BR/204/18/PL

Replacement of PVCu window to Flat 1 with timber framed window, alterations to existing external entrance to Flat 6, installation of wrought iron gates to bin store, installation of fire alarm system & fire doors to communal areas & restoration (decorative) works to exterior of building, communal area & Flat 6. This application affects the character & appearance of The Steyne, Bognor Regis Conservation Area.

Bath House 9 The Steyne Bognor Regis
PO21 1TX

BIN STORE
PROPOSED PLANS, ELEVATIONS, SECTION

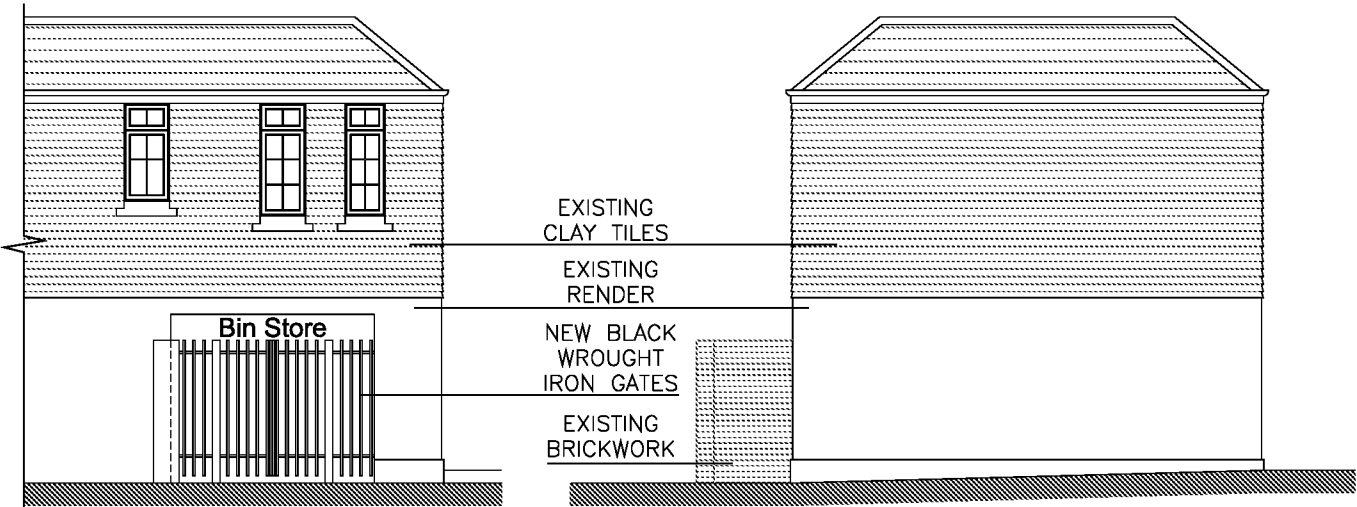
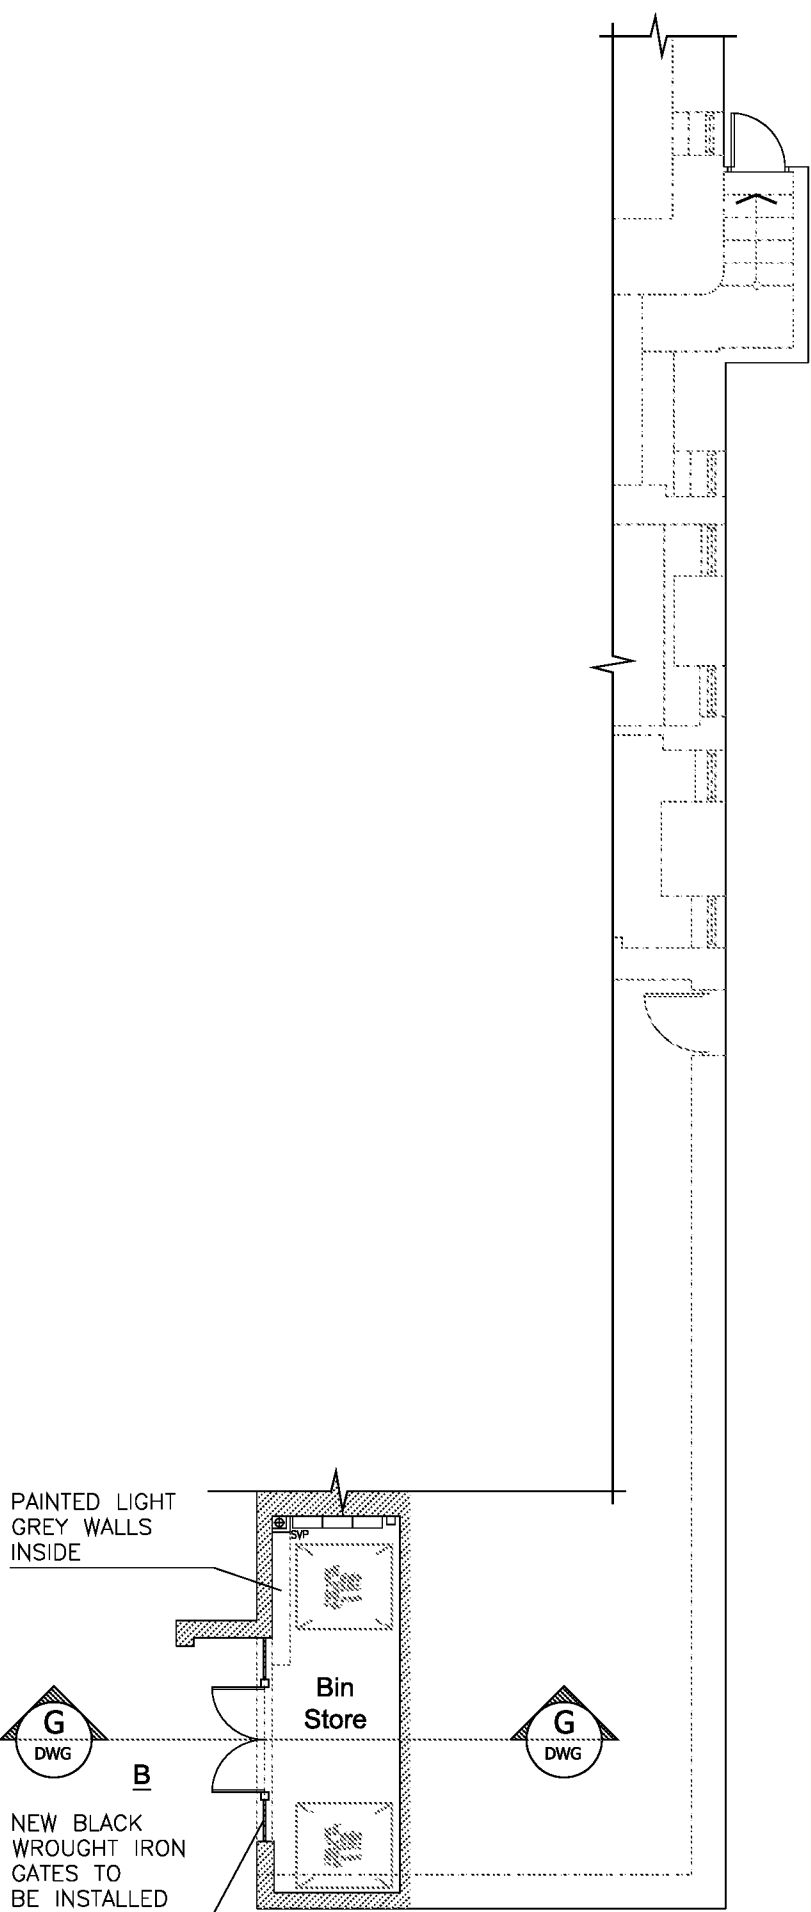
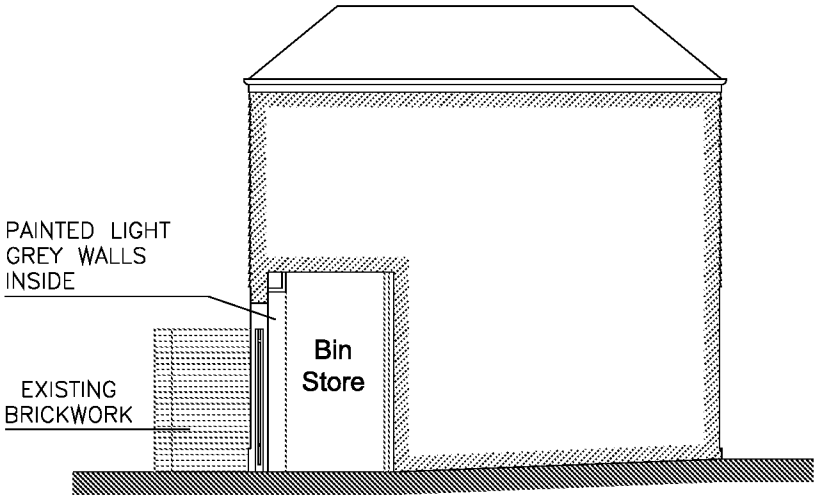
Window should have balance sashes and quality of joinery & wrought iron
